PLAN-008038

Proposal: Rear extension and garage conversion.

Site: 31 Swandene, Bognor Regis, PO21 4UR.

P/112/14/HH

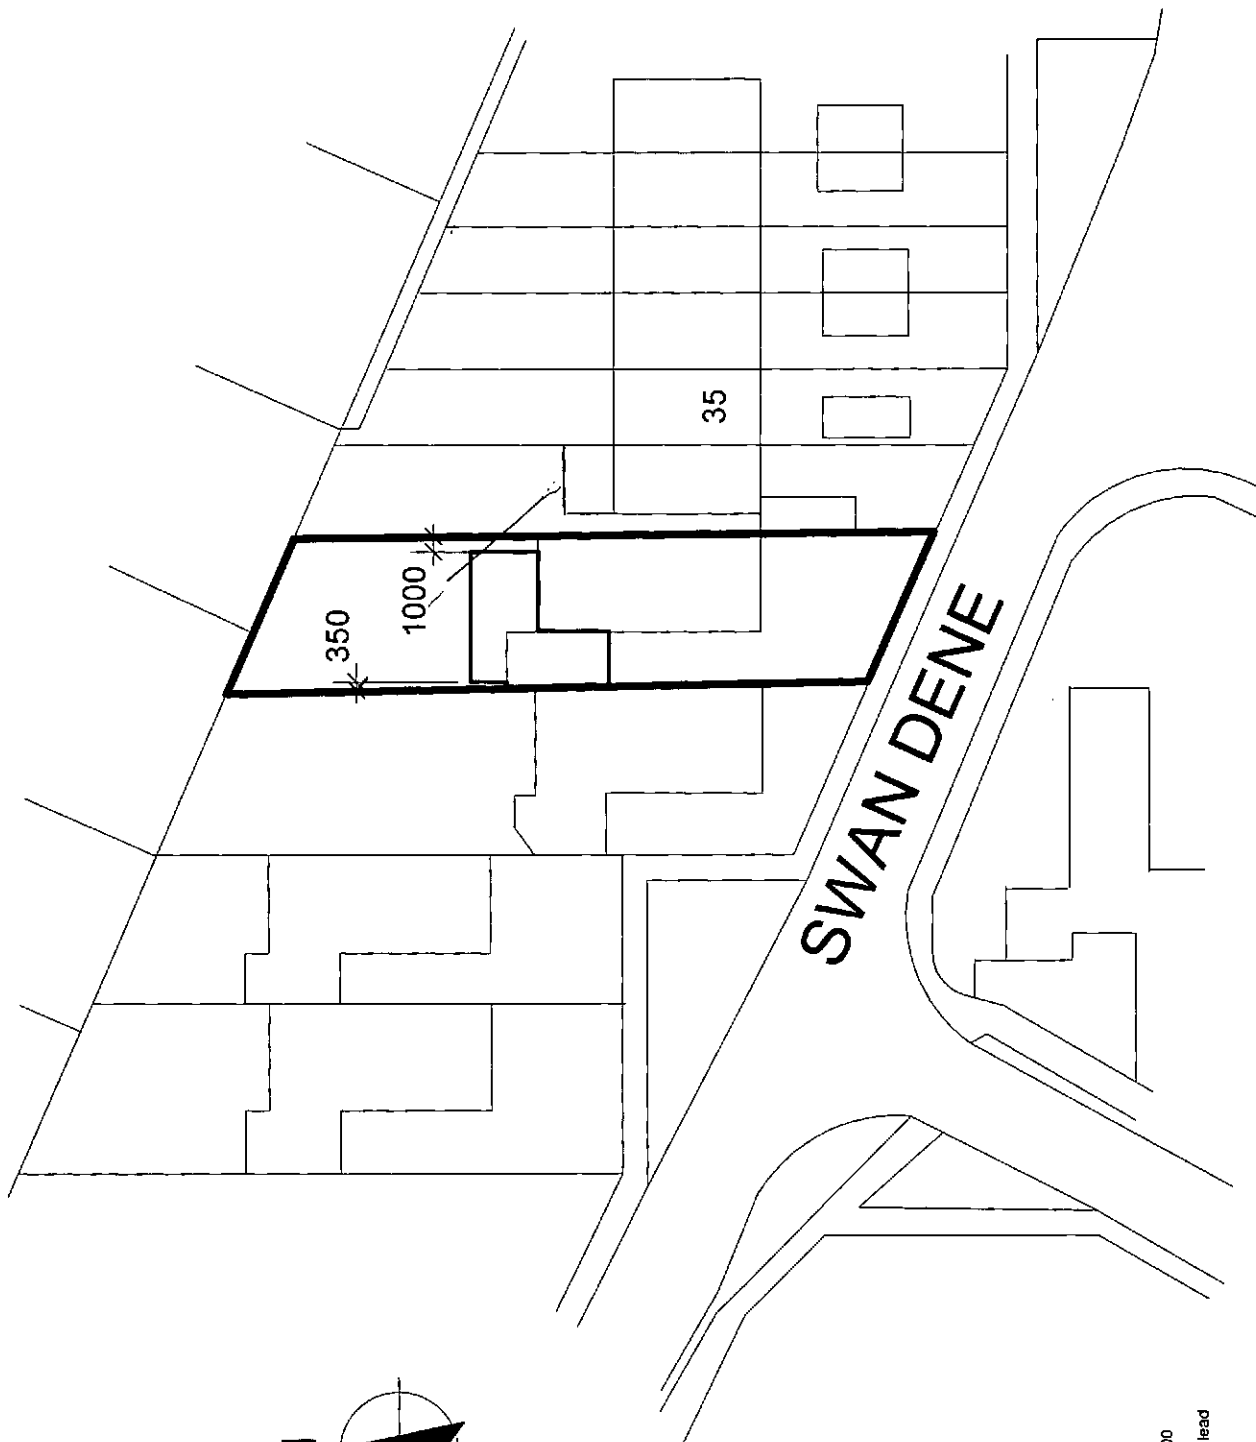
Please find attached a plan of the sewer records showing the approximate position of a public foul rising main sewer crossing the site. The exact position of the public sewers must be determined on site by the applicant before the layout of the proposed development is finalised.

From our initial assessment of the existing apparatus it appears that there is limited opportunity to divert existing drainage apparatus, and therefore Southern Water objects to the proposed development. If planning permission were to be granted, Southern Water (as the statutory sewerage undertaker) would request that the Council (as the Building Control Authority) refuse Building Regulations approval on the grounds that building over the public sewer cannot be permitted.

The 125 mm diameter foul rising main requires a clearance of 3 metres either side of the sewer to protect it from construction works and allow for future access for maintenance.

-No development or new tree planting should be located within 3 metres either side of the centreline of the public sewer

-No new soakaways should be located within 5 metres of a public sewer.

In order to progress the proposed development on the site, the layout must be amended. In considering an amended layout:
